Response to the Examining Authority’s written questions (EAQs) dated 3 August 2015

Interested Parties Ref: NWWFC-AFP012 and NWWFC-AFP011

Mr Dewi Parry and Mrs Helen M Parry

Figure 11.1: Study Area – Tourism Assessment Study Area

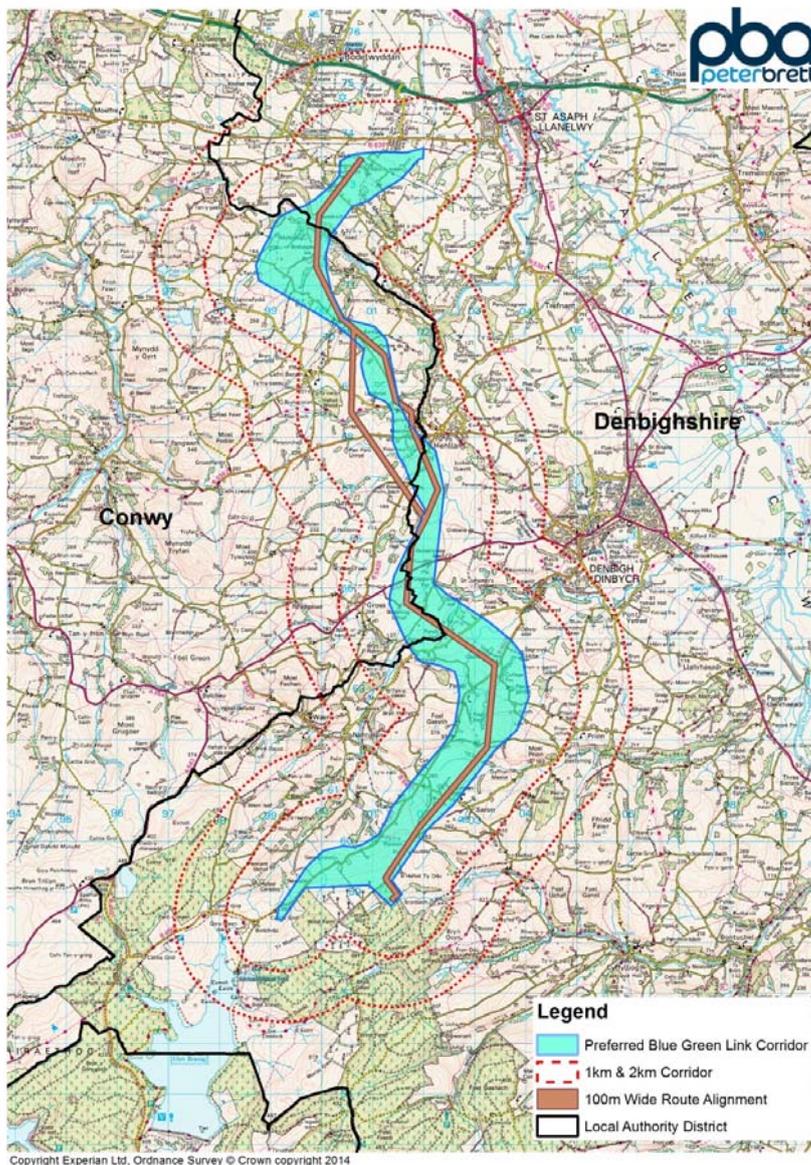
10.1	Interested Parties	Paragraph 11.8.13 of the Socio-economic and tourism chapter of the ES (Chapter 11) states that the proposed development is likely to have a negligible/low adverse effect on the area's tourism economy and in terms of overall significance (paragraph 11.8.15), the development is unlikely to have any significant adverse effects on the overall tourism economy during eth construction, operation and decommissioning phase. Do IPs agree with this statement? If not, why not?
------	--------------------	---

In our view the Applicant has not demonstrated that the development would have a 'negligible/low adverse effect on the area's tourism economy' for the following reasons:

Paragraph 11.6.5 of the Socio-Economic and Tourism chapter of the ES quotes the text used to communicate with the respondents for the survey. We note that it conveniently avoids any reference to 'pylons' or even the size of the double-pole structures or how they may appear in the landscape. It simply refers to a 132kv line.

There is no record of any further information given to the respondents to enable them to give an informed opinion on visual impact and we don't know how many, if any, of the respondents were already familiar with the proposed scheme as that question was not asked. Furthermore, paragraph 11.6.4 states "*Some felt they did not have time to provide a full response*".

The final sample size of only 15 respondents in total (paragraph 11.6.7) combined with factors already mentioned is not a sufficiently sound basis for the Applicant's claim of 'negligible/low adverse effect on the area's tourism economy'.
